**HERITAGE COUNCIL OF NSW – COMMENTS ON DRAFT 2A GREGORY PLACE HOUSING  
CONCEPT – 2 MARCH 2021**

At its meeting on 2 March 2021 the Heritage Council Approval Committee considered the above draft proposal and provides the following comments:

CONCEPT DA-EIS MASTERPLAN

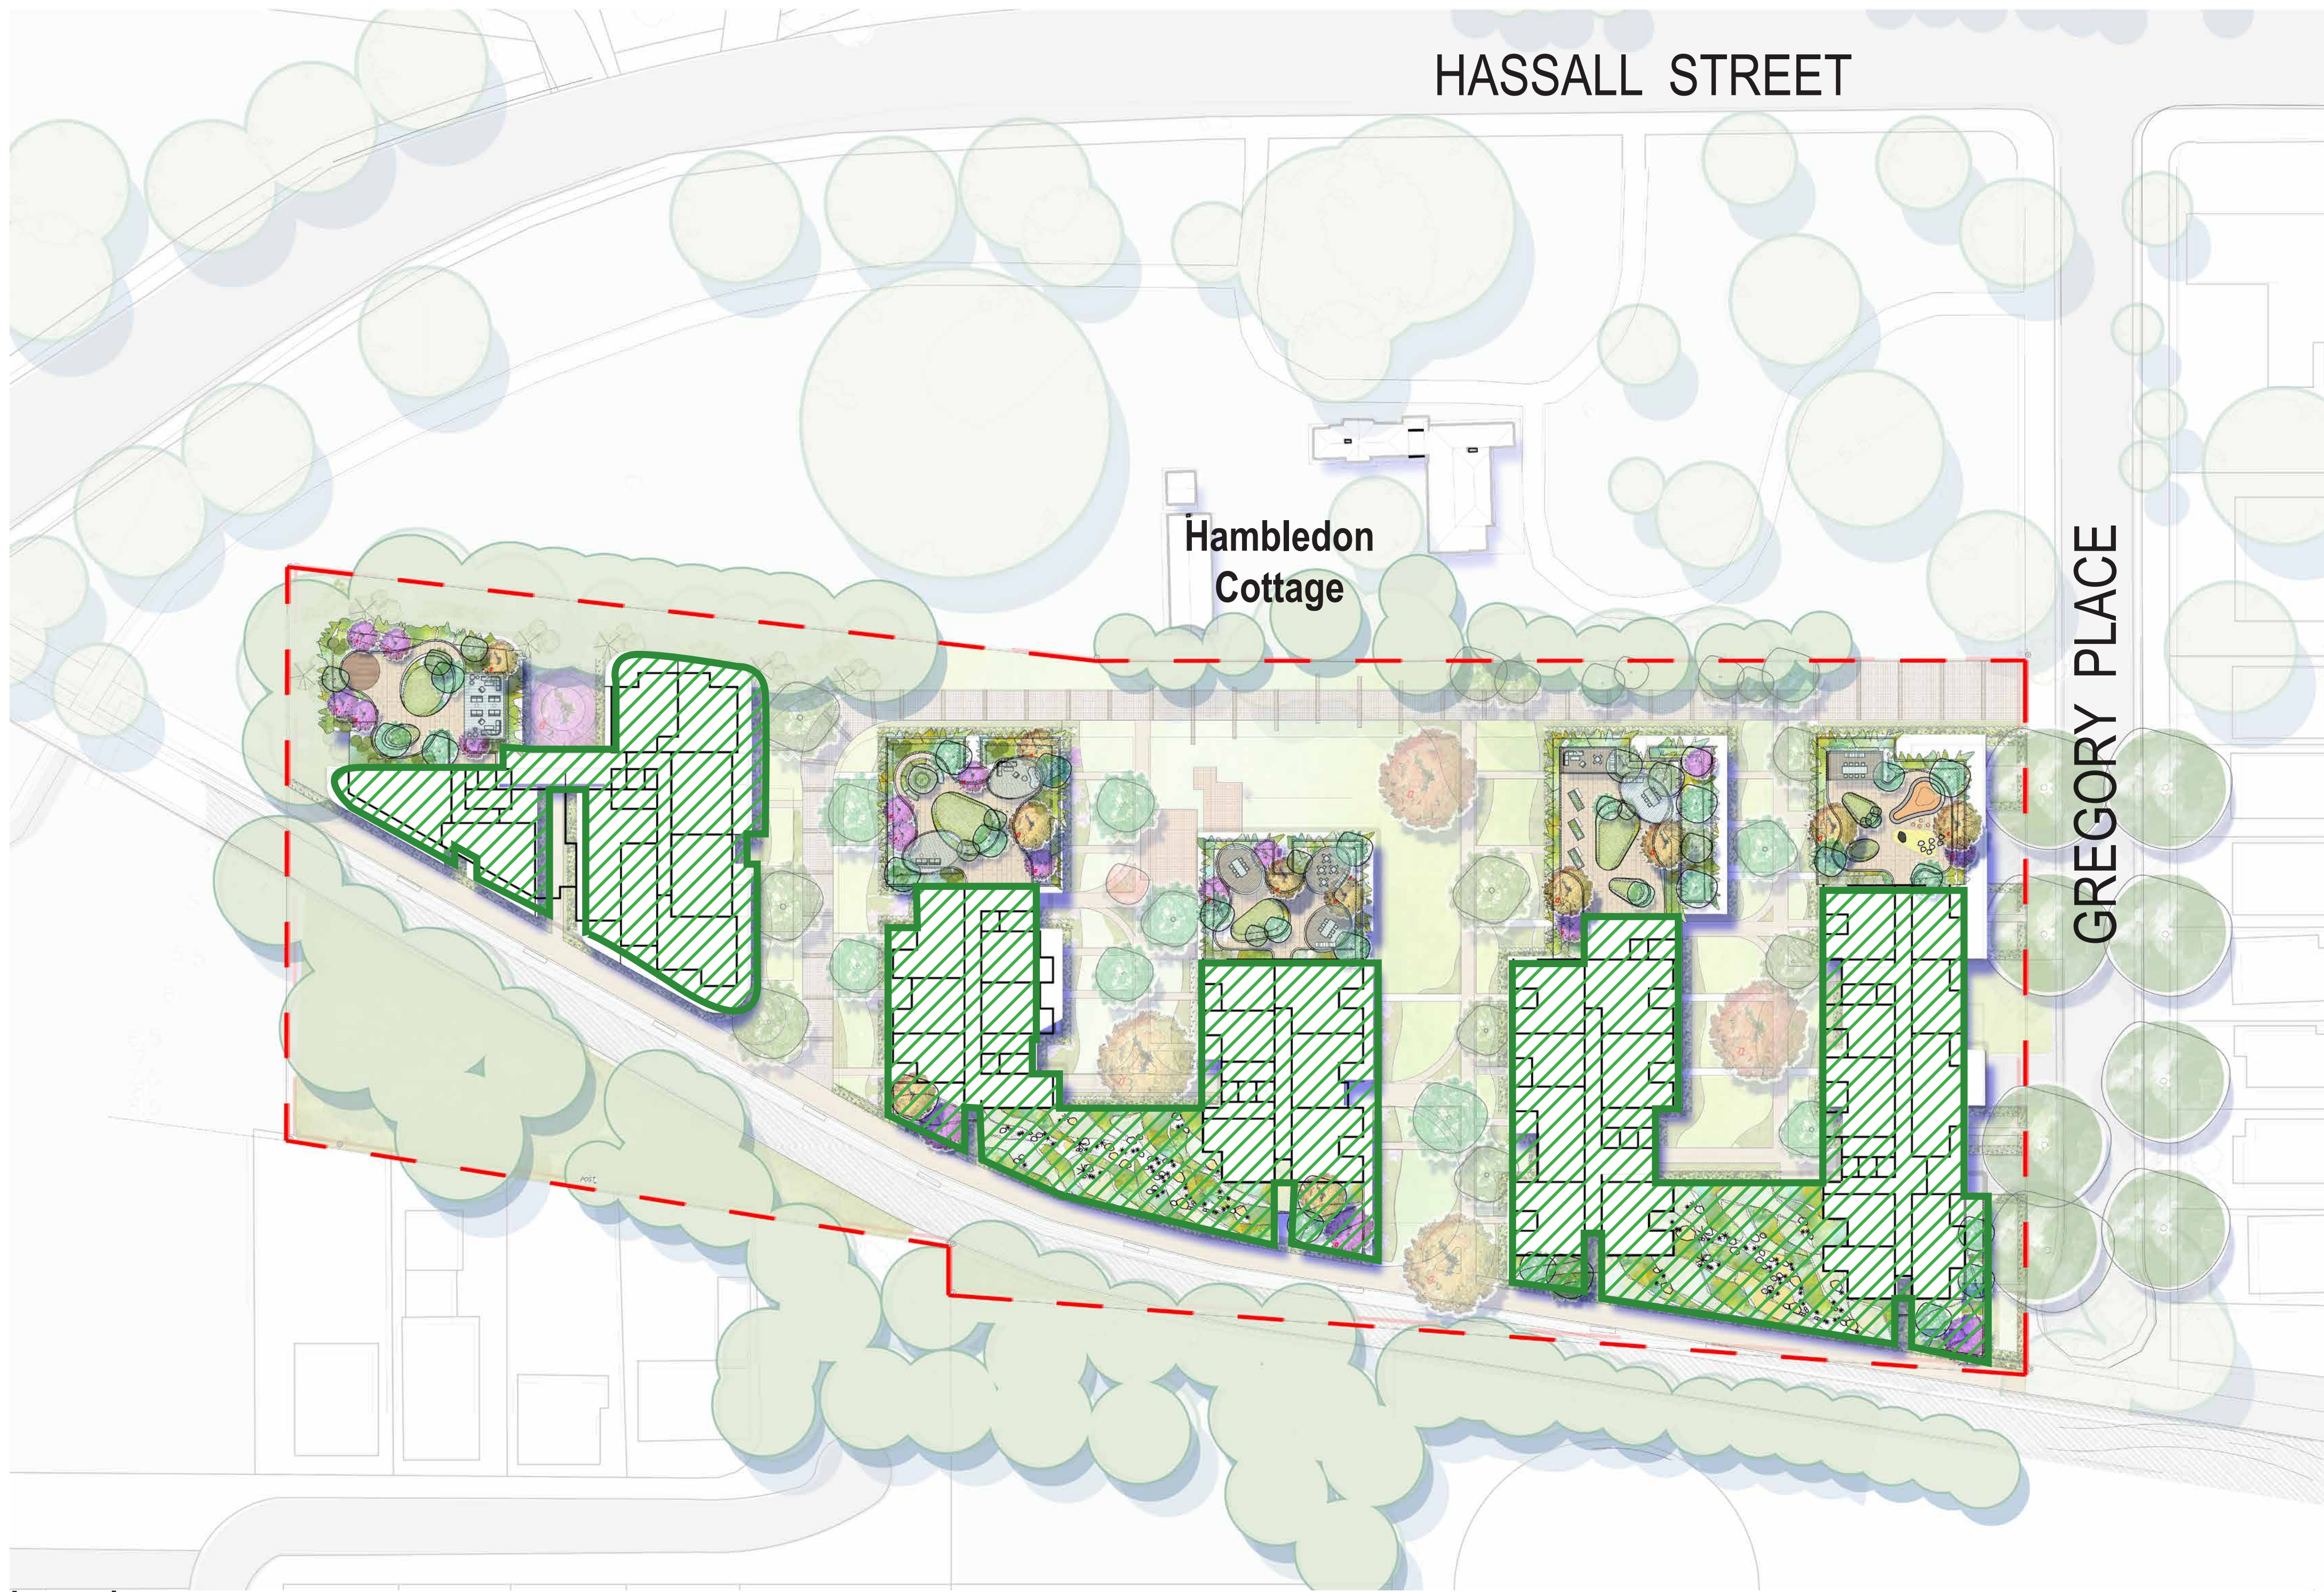
4. Supports progression of the scheme to Stage 1 Development Application.
5. Provides the following advice to the applicant:
  - a) Preserve and enhance public access between Elizabeth Farm and Hambledon Cottage.

- b) Interpret the original creek line and re-naturalise the current creek (e.g. by adding reed beds).
  - c) Consider carefully the location and extent of car parking under the building, associated access arrangements and archaeological considerations.
